Central Coast Community Better Planning Group
c/o Community Environment Network
PO Box 149
Ourimbah 2258
4 August 2026

RE: OBJECTION TO STATE SIGNIFICANT DEVELOPMENT APPLICATION SSD-83538214 — MIXED USE DEVELOPMENT WITH AFFORDABLE HOUSING, 43-45 BEANE STREET AND 2 KEEVERS LANE, GOSFORD

DCP KEY VIEWPOINTS

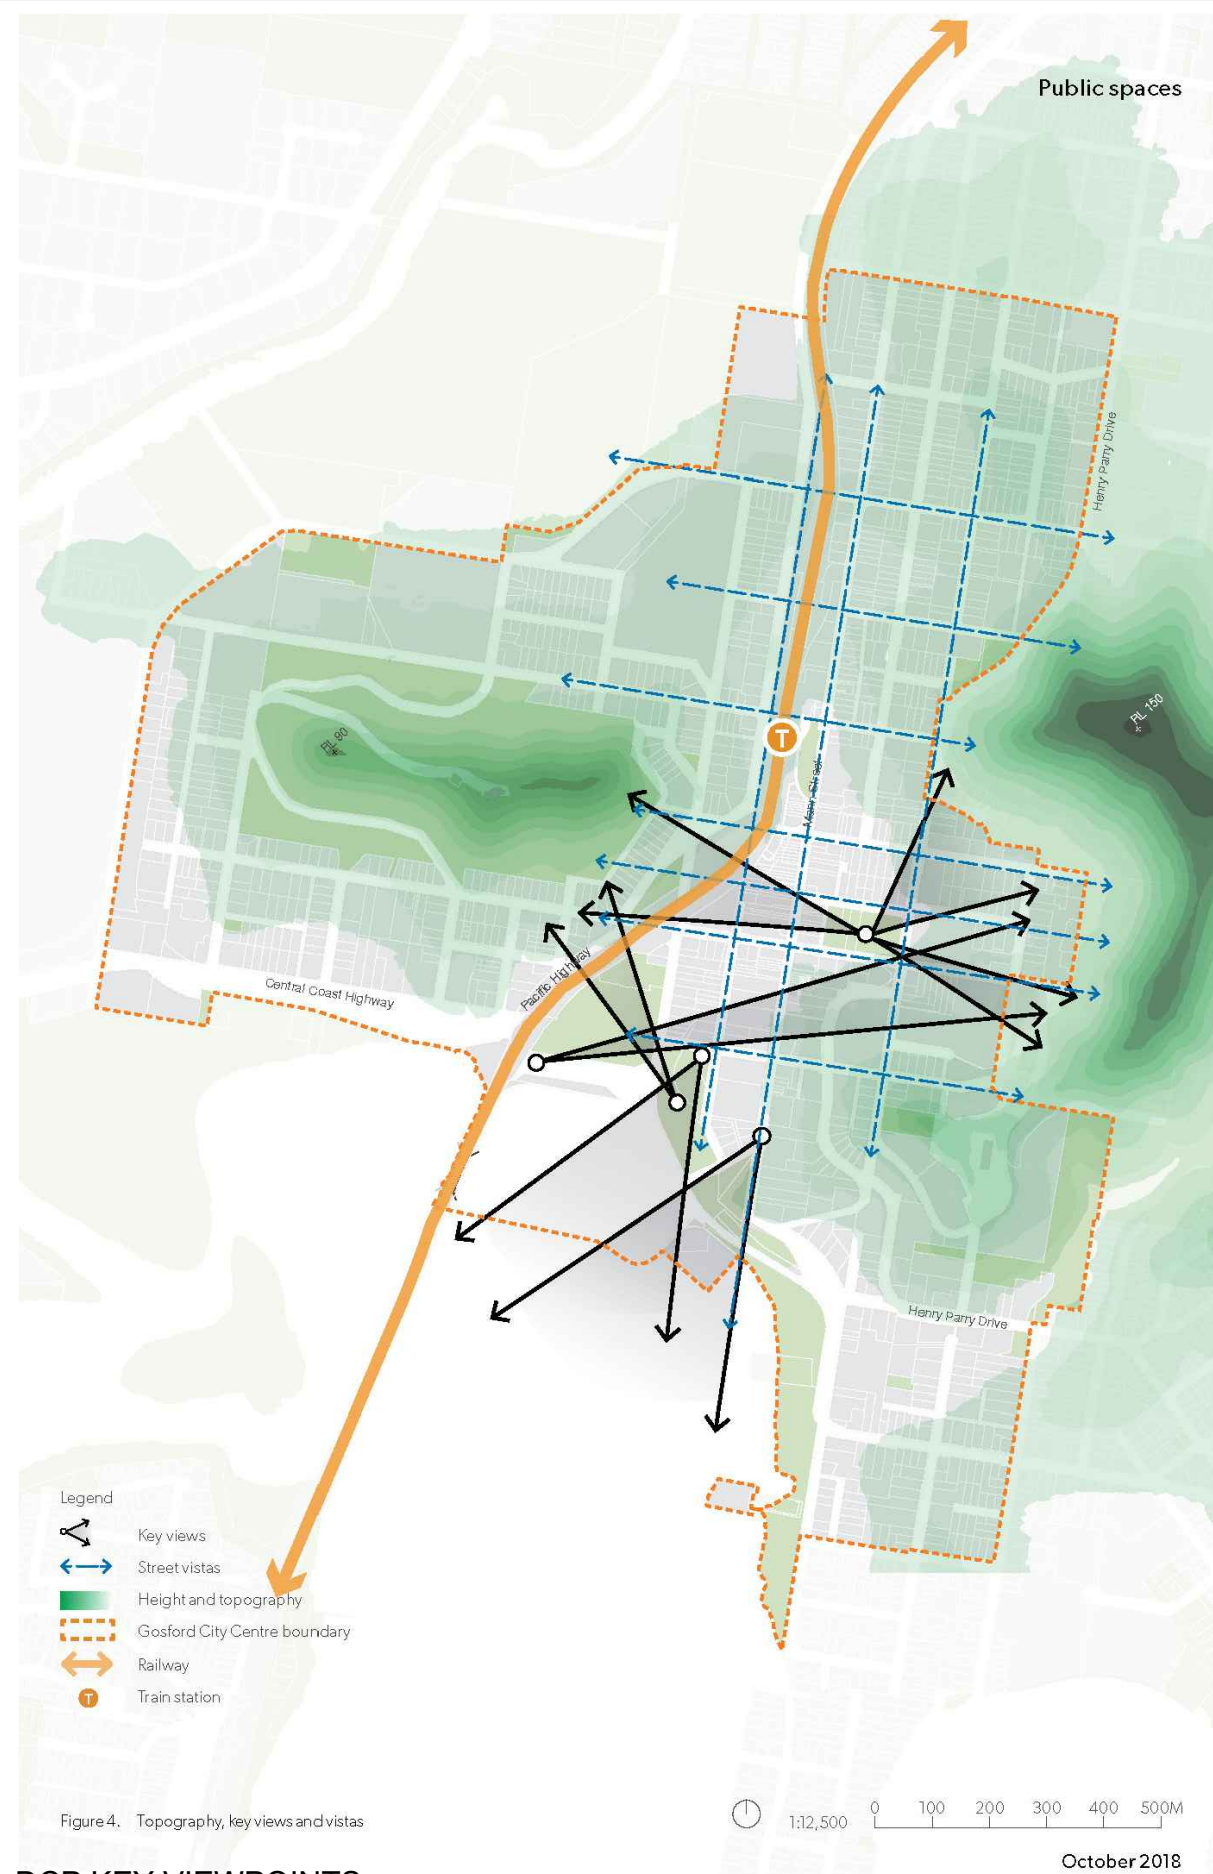
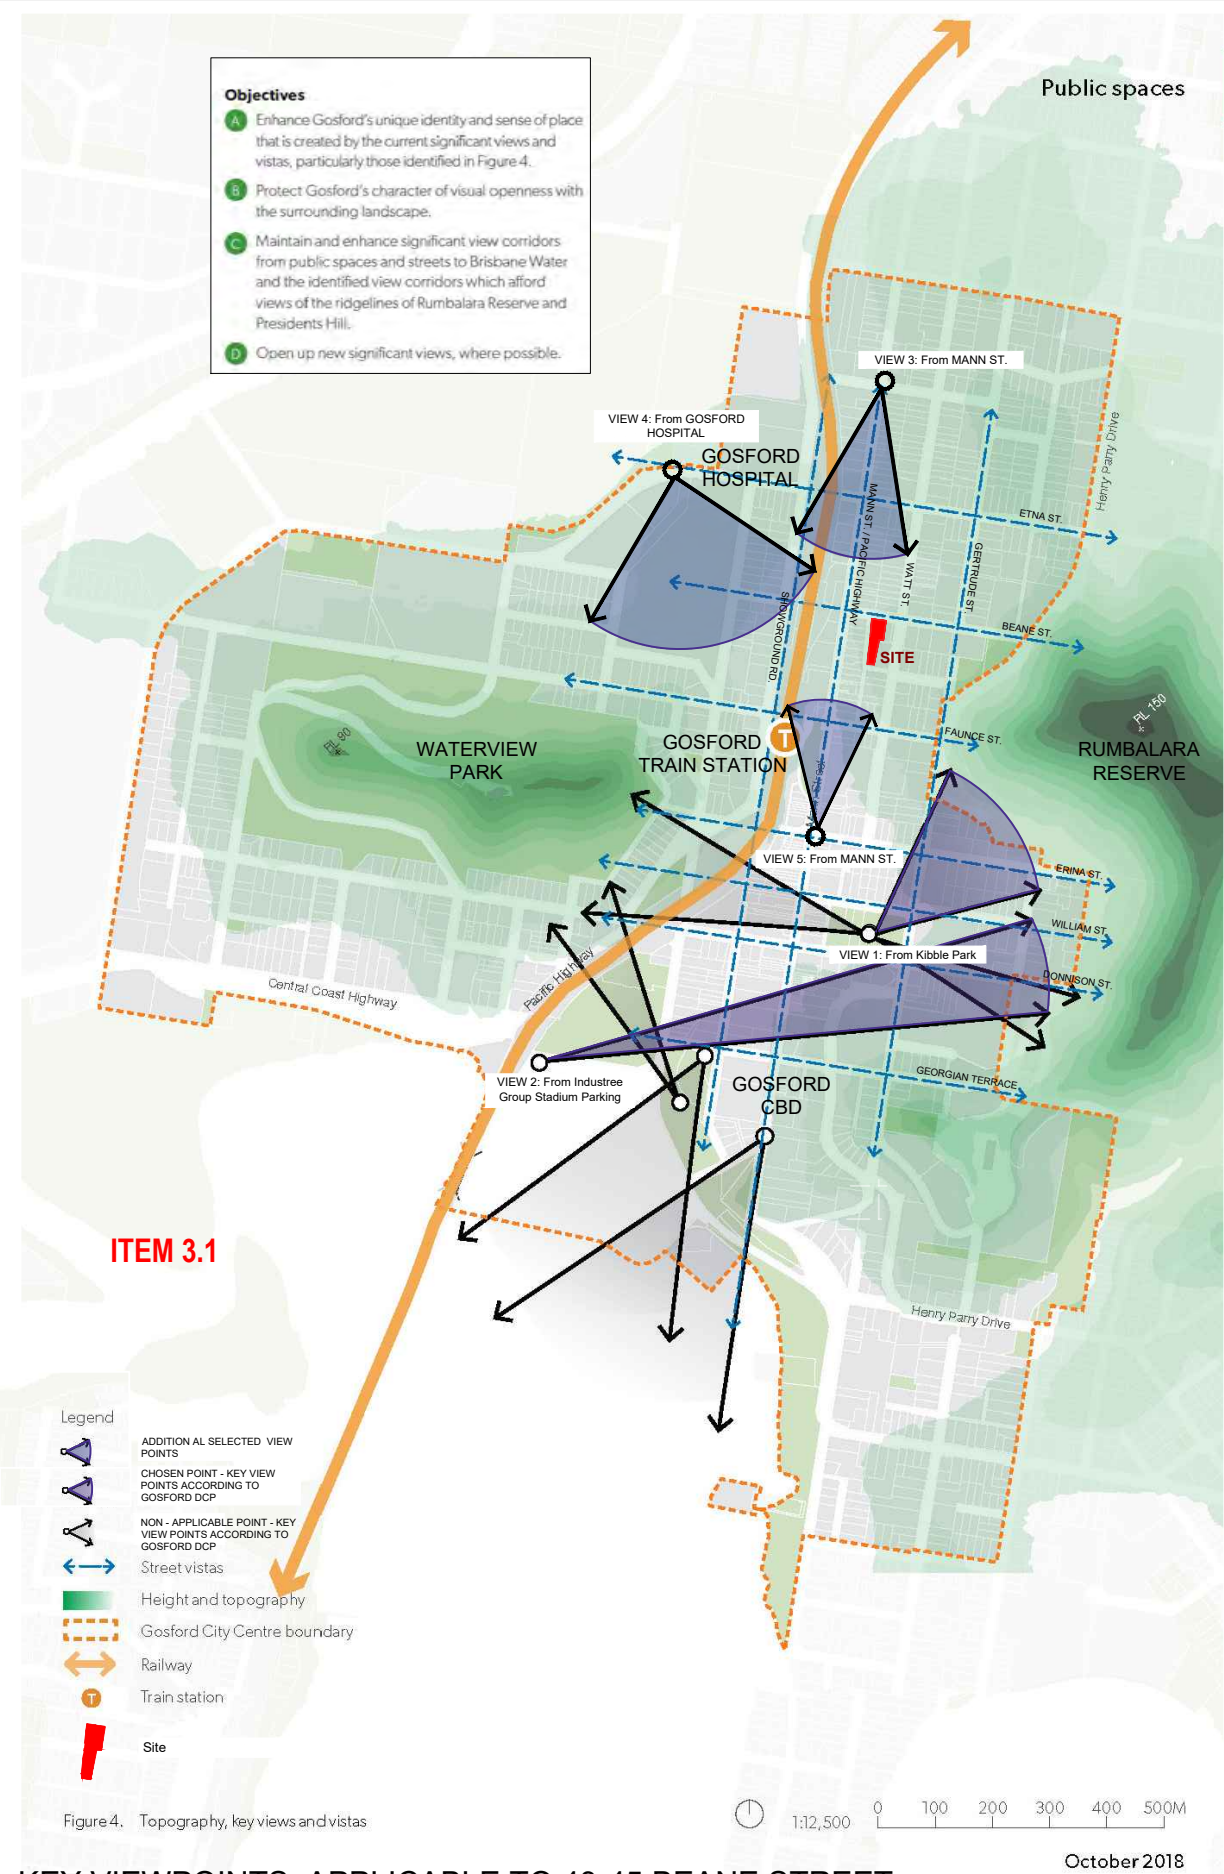
Clause 5.53 of the SEPP (Precincts – Regional) and section 4.4 of the DCP require the protection and enhancement of views of the key landscapes, in particular Rumbalara Reserve and Presidents Hill. The SEPP and DCP also recommend the protection of the vistas of these landscapes along the “primary” streets, such as Beane Street and Mann Street.

The EIS has virtually ignored the vista along Beane Street, even though it is one of the best East-West streets with a view of Rumbalara Reserve. The Visual Impact study appears to have deliberately selected viewpoints, such as Racecourse Road, that have buildings or other obstructions blocking views of the key landscapes.

① BEANE STREET LOOKING SOUTH-EAST

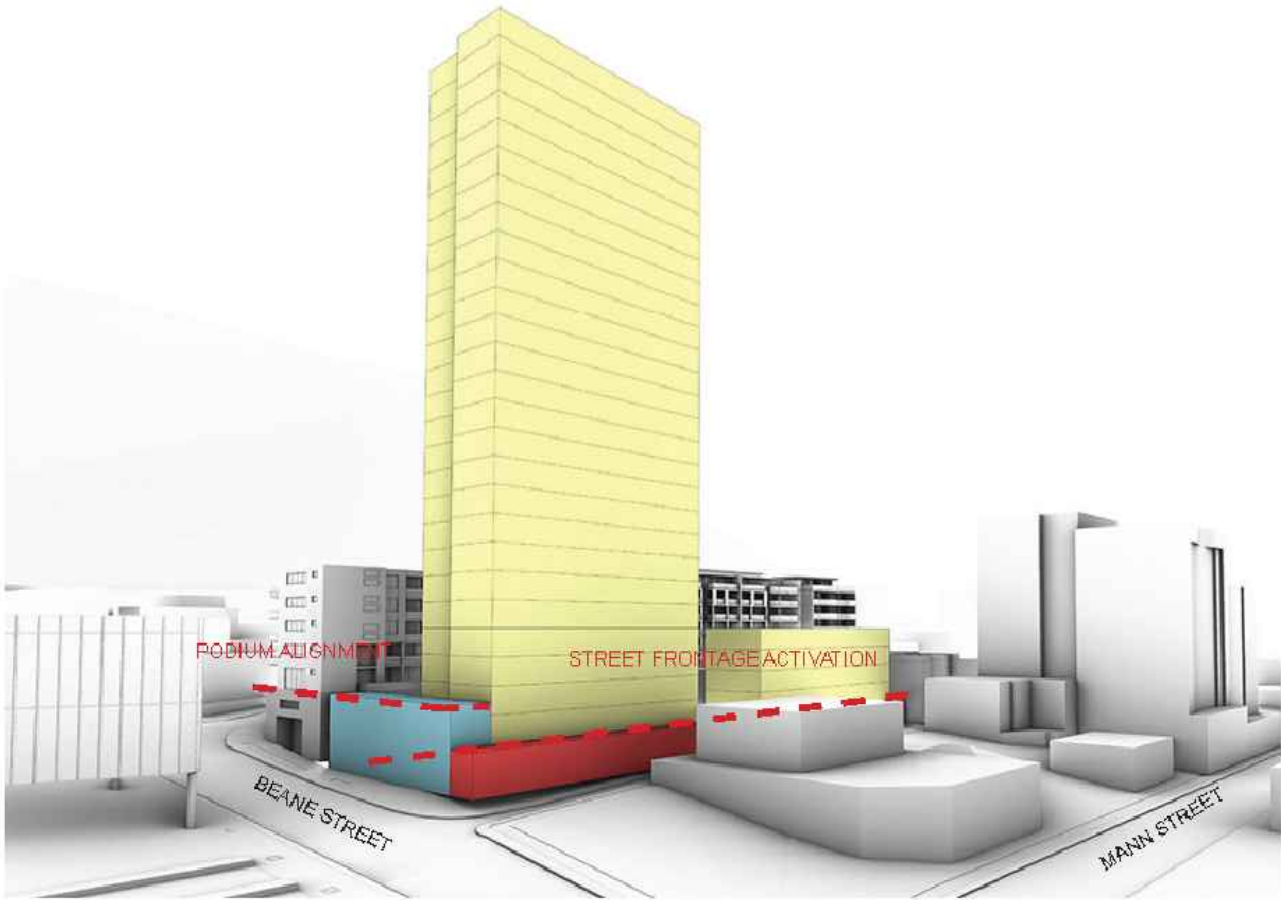
The redevelopment of Gosford Hospital and the creation of a pedestrian corridor between the new parking station and the hospital Main Entrance has provided a fantastic view corridor across the railway and Mann Street then along Beane Street to Rumbalara. The proposed 26 storey tower would create a major obstacle in this view corridor and the tower would ruin a significant vista.

The Department should require the applicant to find viewpoints that are not located behind buildings and redesign the towers so that they do not obstruct significant vistas.
